October 25, 2016  
Code Enforcement Officer  
389 Congress St  
Portland, ME 04101

Re: 49 Wingate Dr, Portland, ME  
Bearing Wall Removal

Drawing file: 1. Original Plans / sketch of proposed beam.pdf

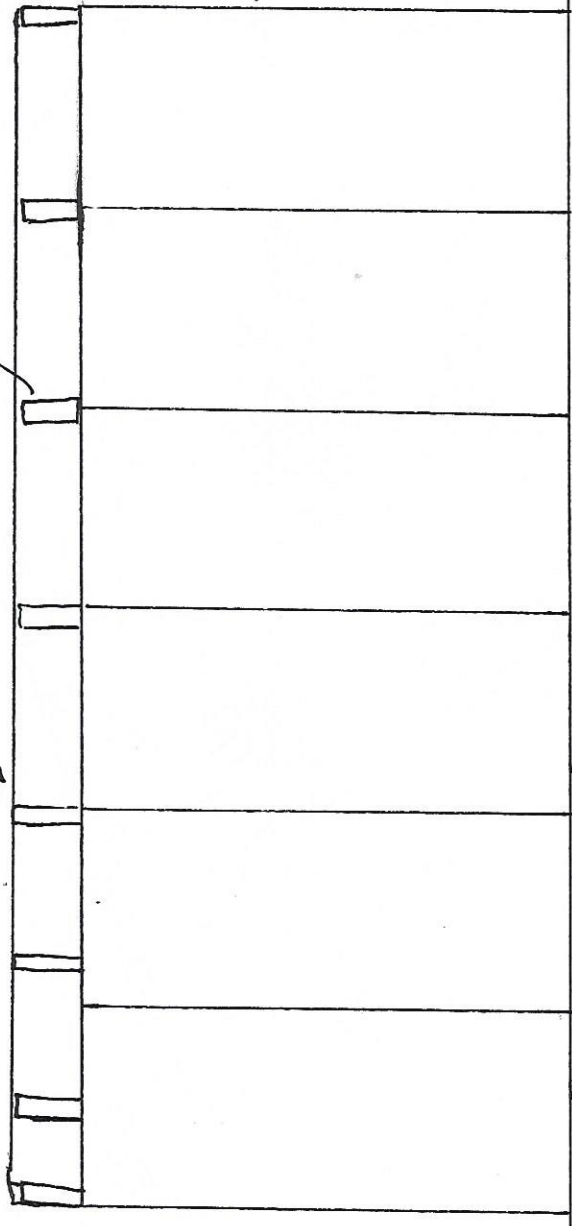
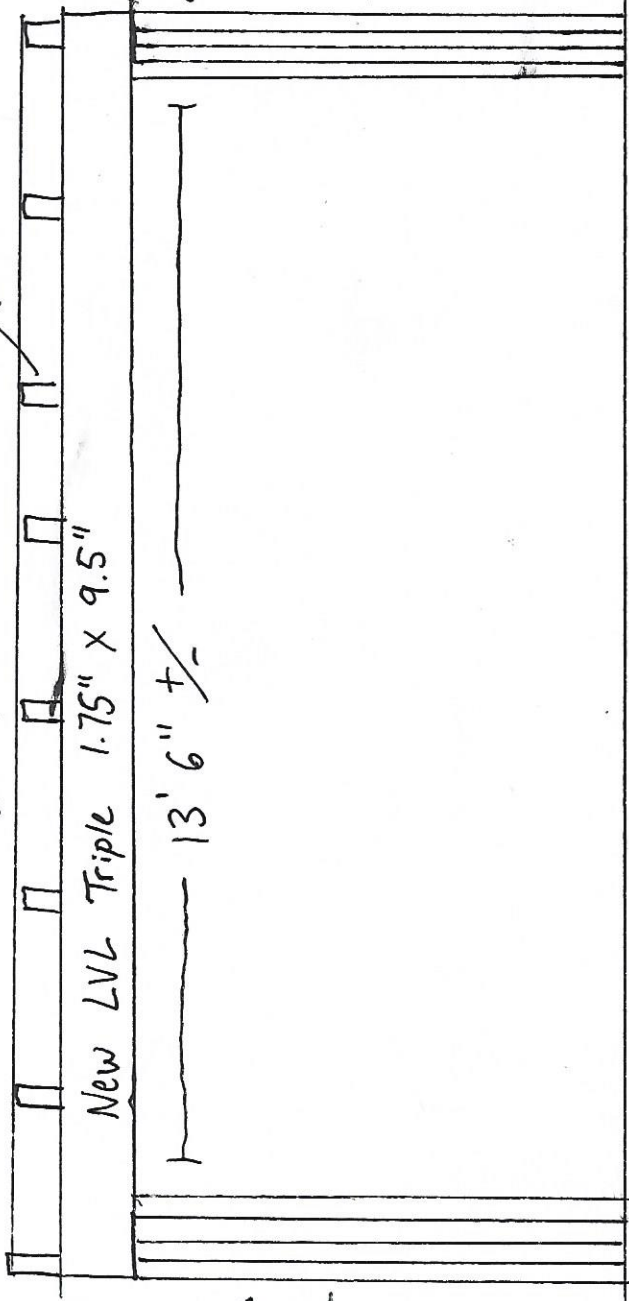
I have visited the above referenced property and observed the existing conditions at the first floor area where a portion of the existing center bearing wall is planned to be removed. The new clear opening will be 13'-6" +/- and the required beam size is a triple 1.75"X9.5" LVL by Boise, with the following properties:

Multiple laminations to be connected with a minimum 2 rows of 16d box/sinker nails at 12" o.c.

Supporting end posts should be minimum 4-2x4's built-up post with Simpson ACE post caps. The new post at the exterior wall will be supported by the foundation wall. The new post adjacent to the stairwell will be supported by an existing concrete filled lally column at the basement. Refer to the attached sketch (by others) for additional information.
